**RE: SUBMISSIONS REPORT REVIEW FOR THE MAXWELL PROJECT (SSD-9526)**

WRM WATER AND ENVIRONMENT LETTER  
MAXWELL PROJECT SURFACE WATER ASSESSMENT – RESPONSE TO EPA COMMENTS

## Response to EPA comments

1383-03-C, 11 December 2019

**Figure 3.9 - Maxwell Infrastructure - Water Management Dams**

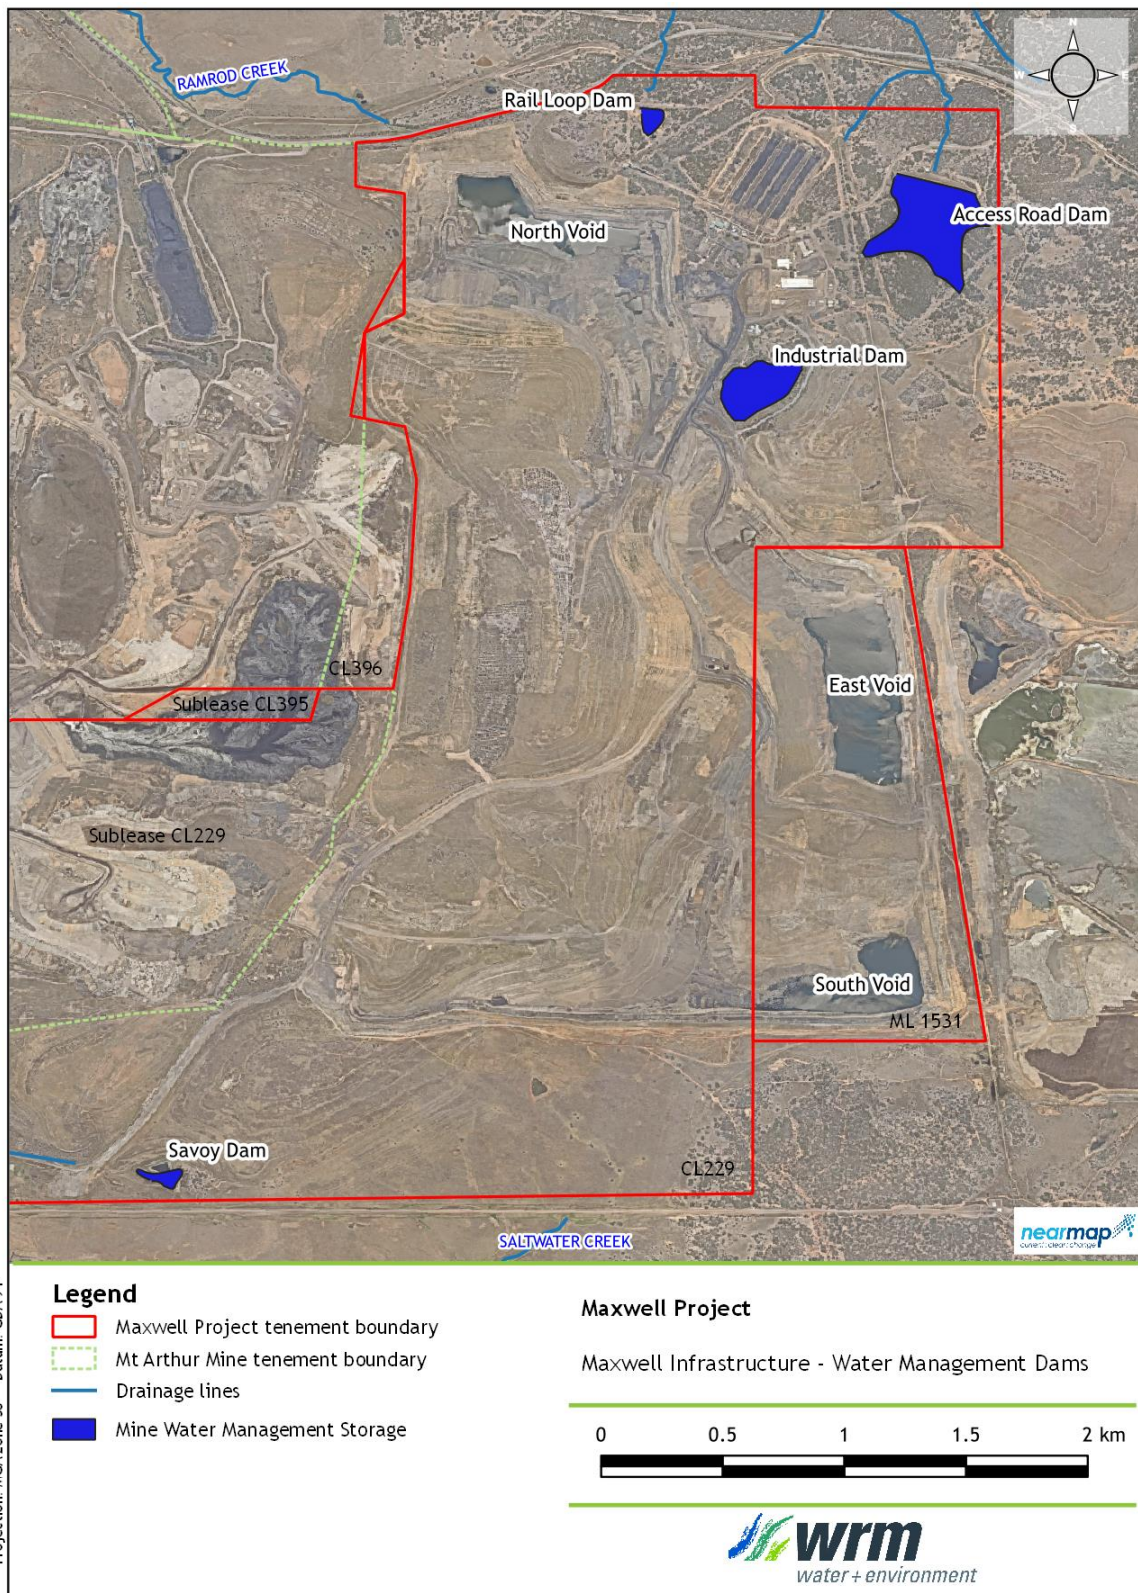
*While the Submissions Report indicates that there will be no controlled discharges from these dams, it states that there is a "1% probability (in any one year) that Rail Loop Dam and Access Road Dam could overflow to Ramrod Creek". This appears to indicate that these dams are predicted to overflow three to four days each year on average. Table 3.9 on page 39 of the Environmental Impact Statement's Surface Water Assessment dated 9 July 2019 (Appendix C), indicates that the water in these dams has an electrical conductivity (EC) of up to 8,180 microsiemens per centimetre ( $\mu\text{S}/\text{cm}$ ).*

It appears the EPA's primary concern relates to their interpretation of the overflow probability (1% probability in any on year) as meaning "*these dams are predicted to overflow three to four days each year on average*". However, it is important to clarify that the above reference to a 1% probability (in any one year) of an overflow from Rail Loop Dam and Access Road Dam means that these dams are predicted to overflow in only 1 of the 103 historical climate sequences that were modelled (i.e. effectively once in 100 years).

The Rail Loop Dam and Access Road Dam are predicted to overflow in only 1 of the 103 historical climate sequences that were modelled.

- During the modelled Rail Loop Dam overflows, a dilution ratio of at least 200:1 within Ramrod Creek is predicted.
- During the modelled Access Road Dam overflows, a dilution ratio of at least 30:1 within Ramrod Creek is predicted.

This indicates that the modelled overflows to Ramrod Creek would only represent between 0.5% and 3.3% of the flow in the receiving environment (at the Hunter River confluence). That is, the predicted overflows would have a negligible volumetric impact on Ramrod Creek.

The predicted salinity of modelled overflows from Rail Loop Dam and Access Road Dam is between 1,750 and 4,500  $\mu\text{S}/\text{cm}$ . This indicates that the salinity of overflows from Rail Loop Dam or Access Road Dam would likely be similar or better quality than the receiving waters.

In addition, given the expected dilution ratios within the receiving waters during overflows, any overflows from these dams would have a negligible impact on the water quality in Ramrod Creek.

Further, it is noted that the water balance model is run on a daily time step, which may overpredict the likelihood of overflows. Should an overflow be imminent, Malabar could rapidly increase the pumping capacity in Access Road and Rail Loop Dams to reduce the likelihood of an overflow.
